Hear Gold Project PA 10_0191 MOD 3 -EA Exhibition

NSW Department of Industry, Division of Resources & Energy (the Division) has reviewed the *Environmental Assessment for Hera Mine Modification 3*, dated August 2015 and provides the following comments within its area of responsibility.

Figure 3: Final Landform and End Land Use

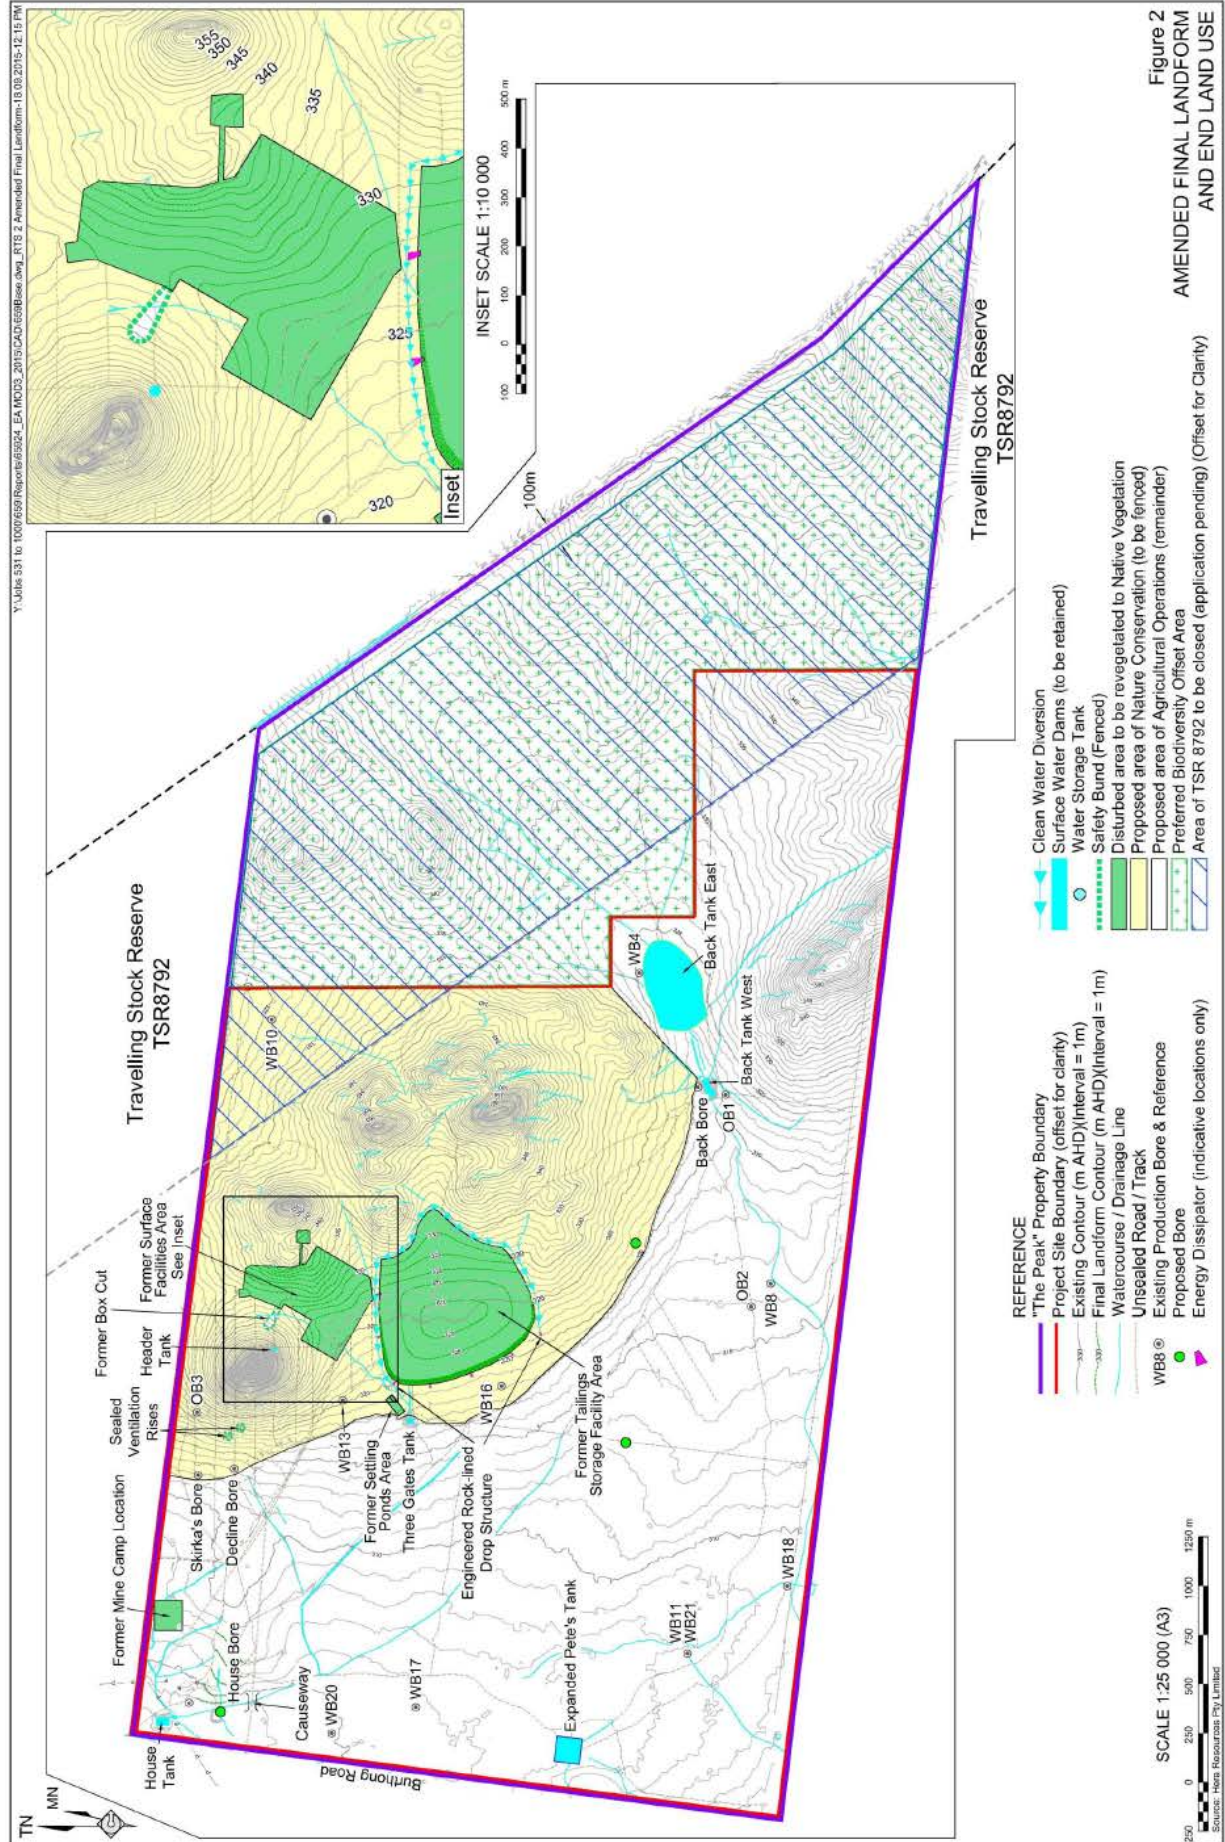
The EA does not provide detail of the revised final landform figure and that there is no a definitive commitment to the remove of material stockpiled at the proposed Northern WRE.

The Division requires a figure that depicts the proposed final landform and land use(s) for the project area, and surrounding undisturbed environment. Include contours, vegetation types, drainage infrastructure and any other retained built infrastructure; and confirmation that there is no change to the current commitment to completely remove all stockpiled waste rock prior to closure as described in the 2011 EA.
